Subject: RE: Nyton House care home dementia ward AL/42/19/PL

We would welcome the hiping of the western roof gables. This would also reduce the impact on the occupiers of Knighton Grange (they have partly objected to the impact on their view).

Many thanks for this, and indeed to Martyn for his commentary and feedback. Broadly he is supportive of the scheme, which is fantastic. His principle concern relates to the gabled nature of the new building viewed from Knighton Grange Cottage and the harmful impact that this could cause.

12| Building height comparison

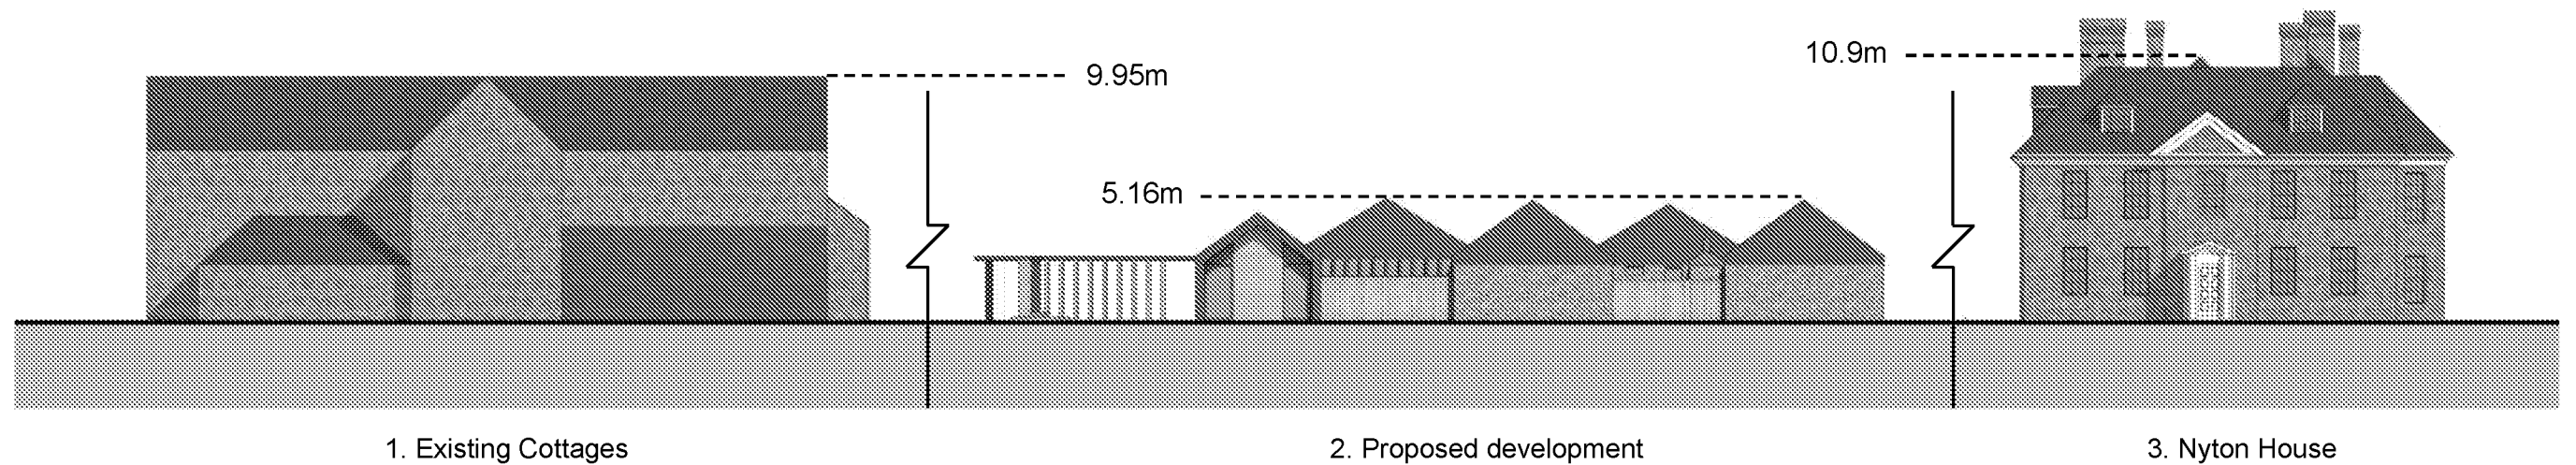
I would like to suggest that, in order to reduce this impact further [we have obviously reduced this enormously already from the initial scheme], we introduce hips to the gabled elements of roof. This will slope the roof of the building away from the boundary and reduce the massing of the apex of wall to a sloping roof face diminishing as it moves away from the neighbouring property.
